From: Ben Kirk [REDACTED]
Sent: 29 January 2019 19:13
To: Andrew Wood
Cc: Ben Kirk
Subject: Re: BN/54/18/DOC - Land North of The Flint Barn - Drainage Conditions

BN/54/18/DOC - Land North of The Flint Barn - Drainage Conditions

Engineers Comments Regarding Conditions 3,4 and 5

Drawing:
Drainage Strategy

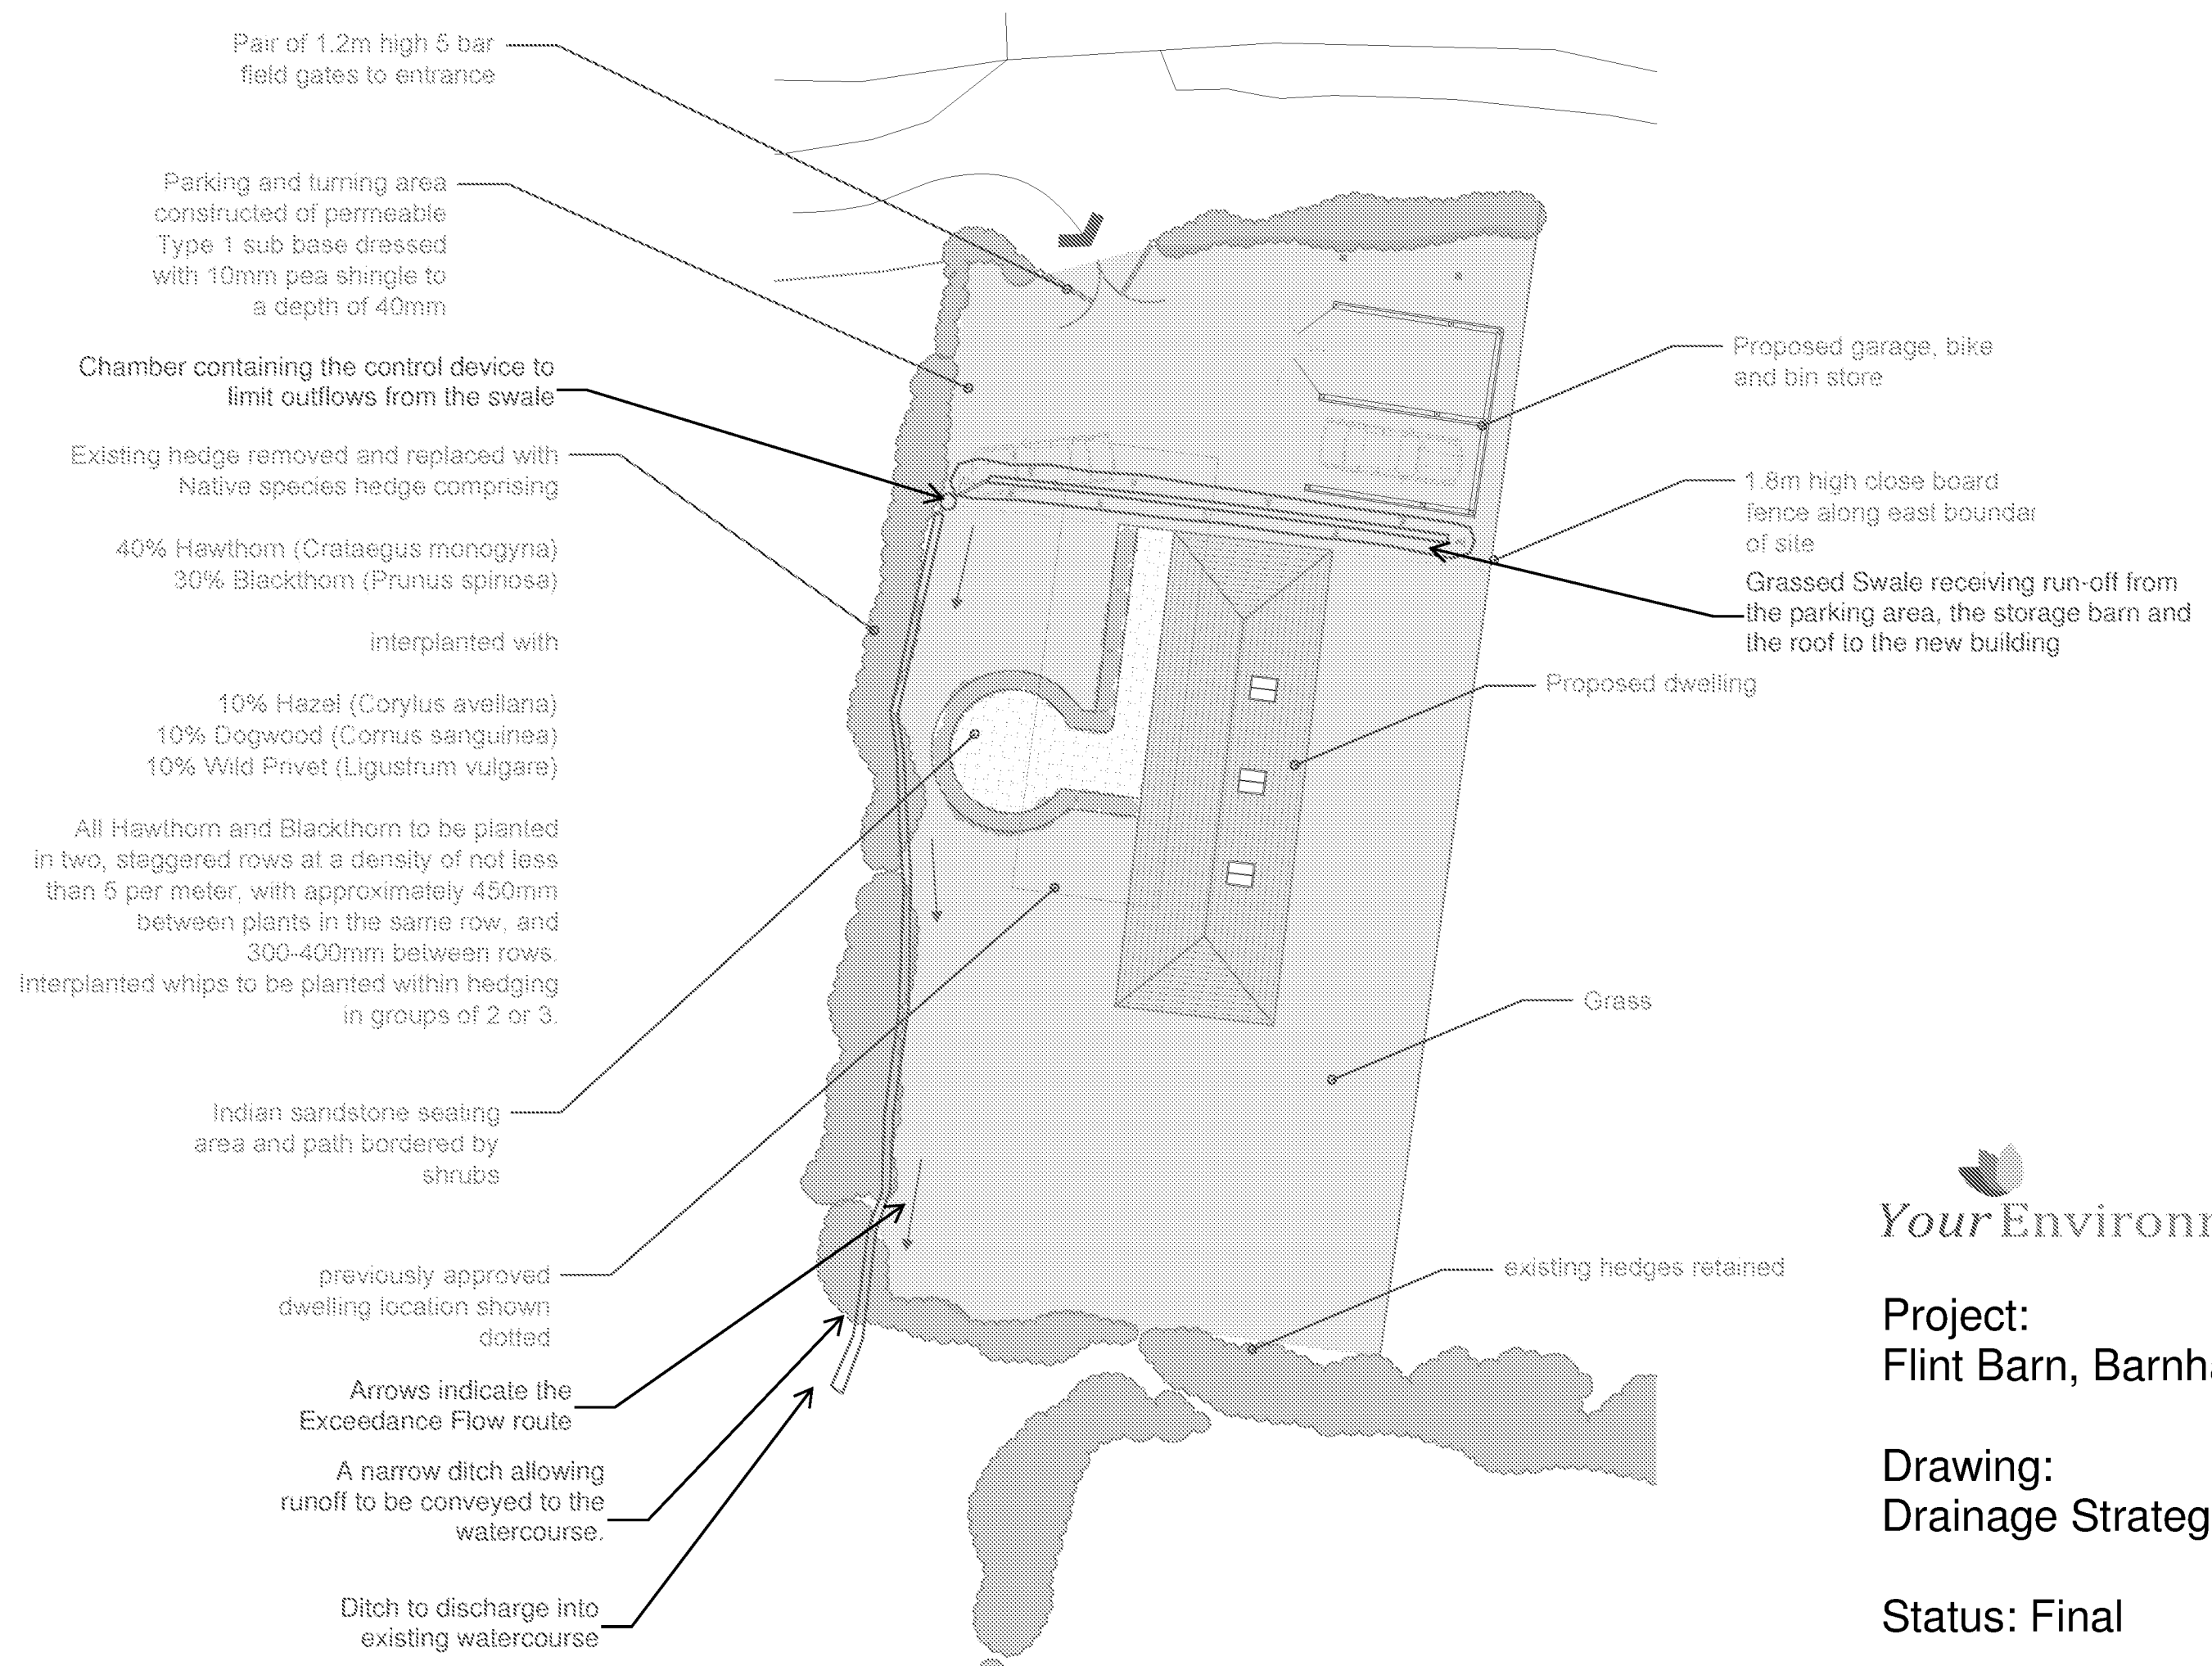
The submitted information is inadequate, and therefore I do not recommend the discharge of this condition.

As stated on the previous application (BN/29/18/DOC) the surface water drainage design must be able to accommodate the 1 in 100 year plus 40% climate change event. Land drainage consent has not been obtained and details are lacking.
